On 1st September, Barnham & Eastergate Parish Council Full Council resolved to submit a no objection response, subject to the following areas of concern being addressed.

Application No: BN/84/20/PL
Registered: 29th July 2020
Site Address: Land at Angels Nursery Yapton Road Barnham PO22 0AY
Grid Reference: 496255 104047
Description of Works: Application for variation of conditions imposed on planning reference BN/43/16/PL relating to Conditions 2 (Approved Plans), 8 (Access/Maintenance of Watercourse or Culvert) and 18 (Access and Associated Off-Site Highway Works).

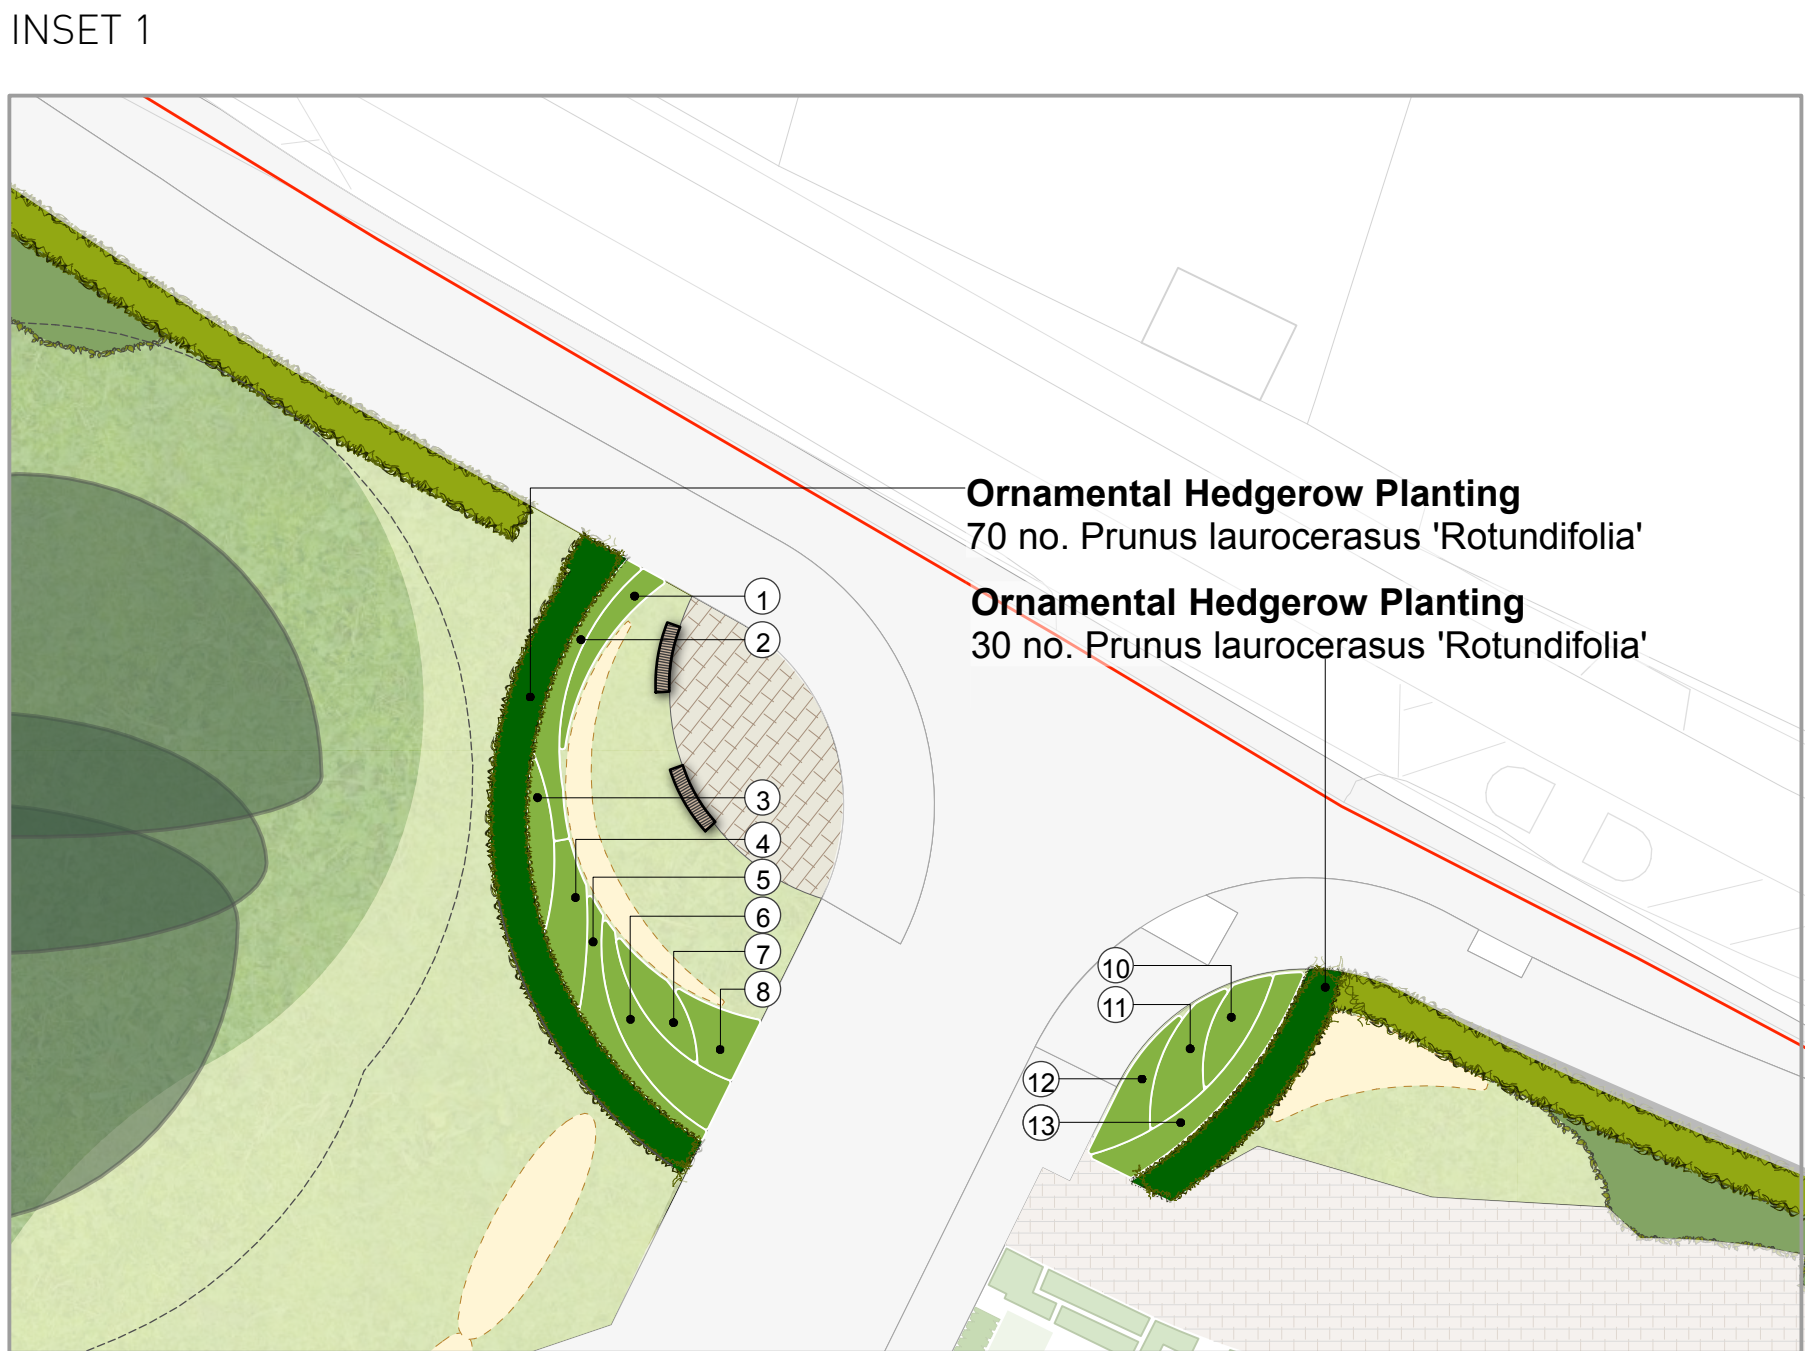
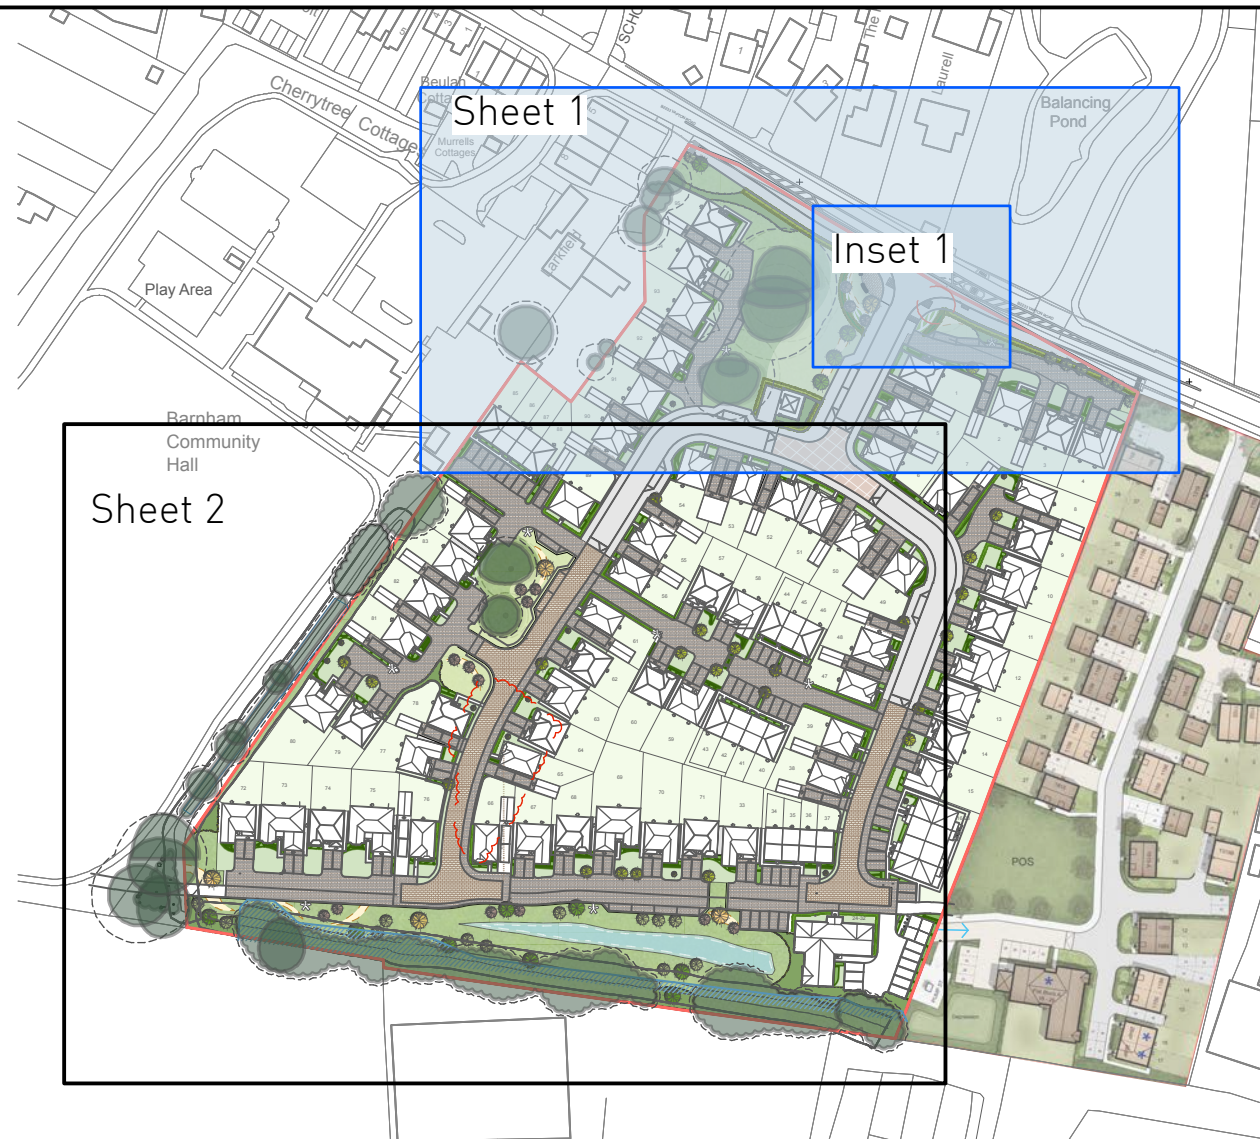
- Provide further and more detailed information in respect of the proposed landscaping plans for the site including the southern boundary, the SUDS (with native hedging not fencing), and planting of native disease-free trees, shrubs (about which Redrow will collaborate with Sussex Wildlife Trust);
